From: Spinks, Denise [mailto:Denise.Spinks@AirservicesAustralia.com]
 Sent: Monday, April 04, 2005 10:32 AM
 To: d.griffin@rpv.com.au
 Cc: Wilson, Michael (ACT); Chalk, Martin; Anderson, Kevin; Owens, Fiona
 Subject: Capital Wind Farm

In relation to the Capital Wind Farm development proposal, our radar engineers have advised that it would cause some minor impact on the Mt Majura primary radar performance.

**ATTACHMENT 8 PATH PROFILE MT MAJURA RADAR – CAPITAL WIND FARM TYPICAL TURBINE**

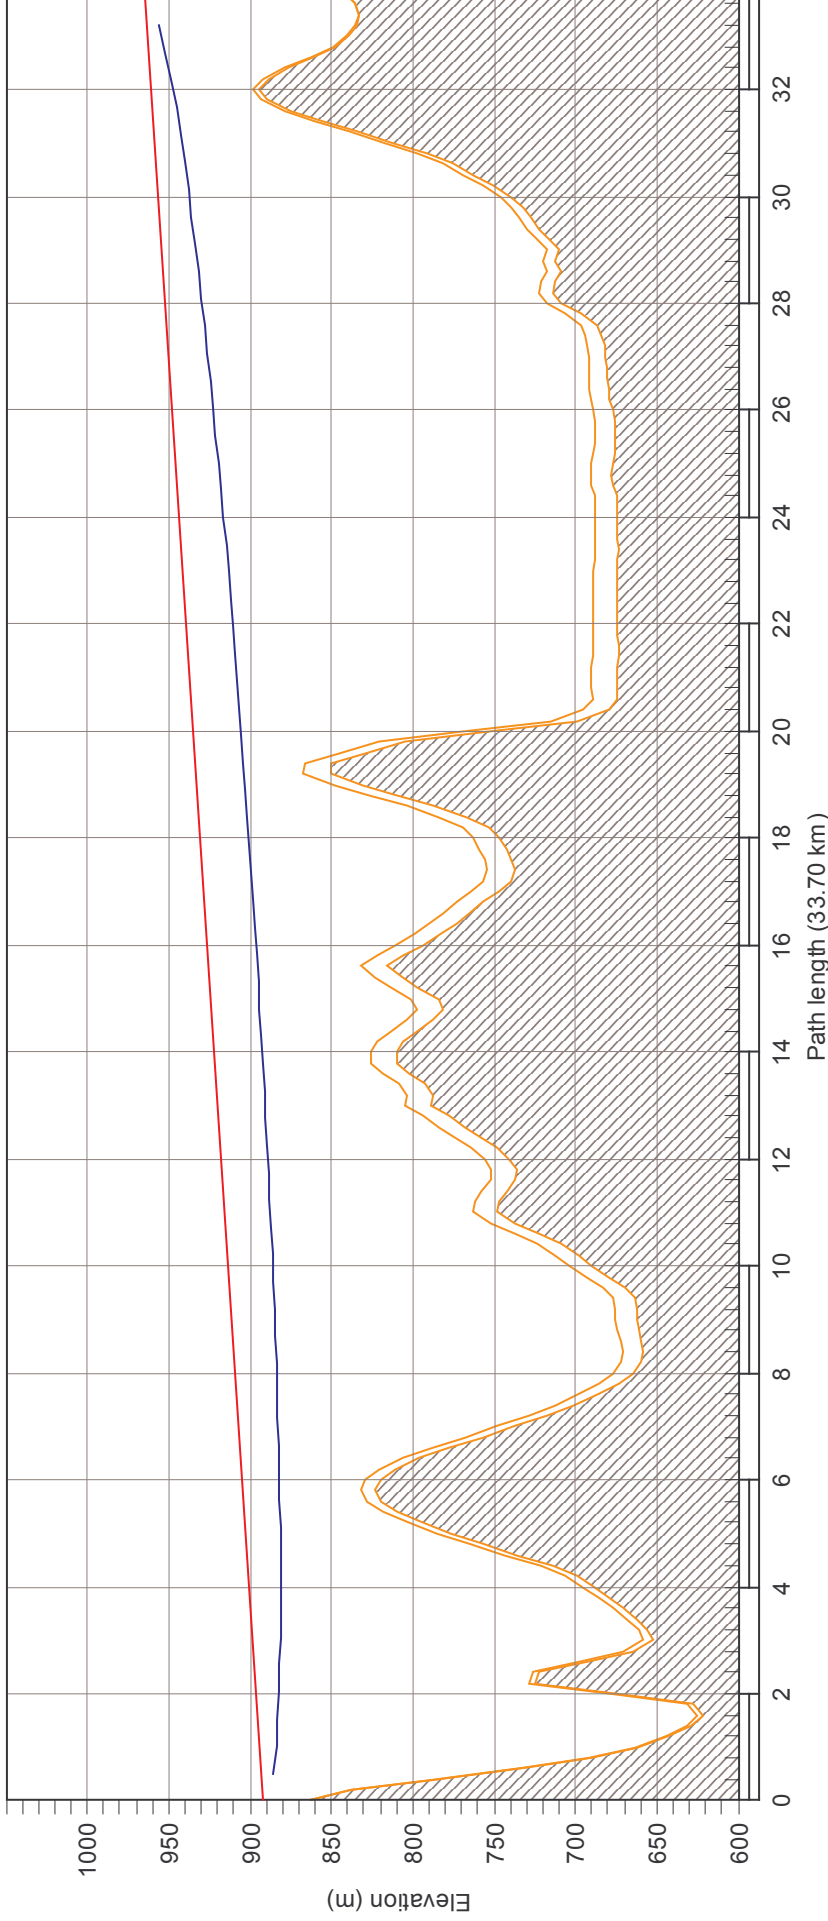
Should the development proceed, Airservices Australia would need to complete works to mitigate that impact and we estimate that this work would require approximately one week's work by a senior engineer. Should the development proceed, discussions would be necessary regarding the cost, timing and scheduling of the necessary works.
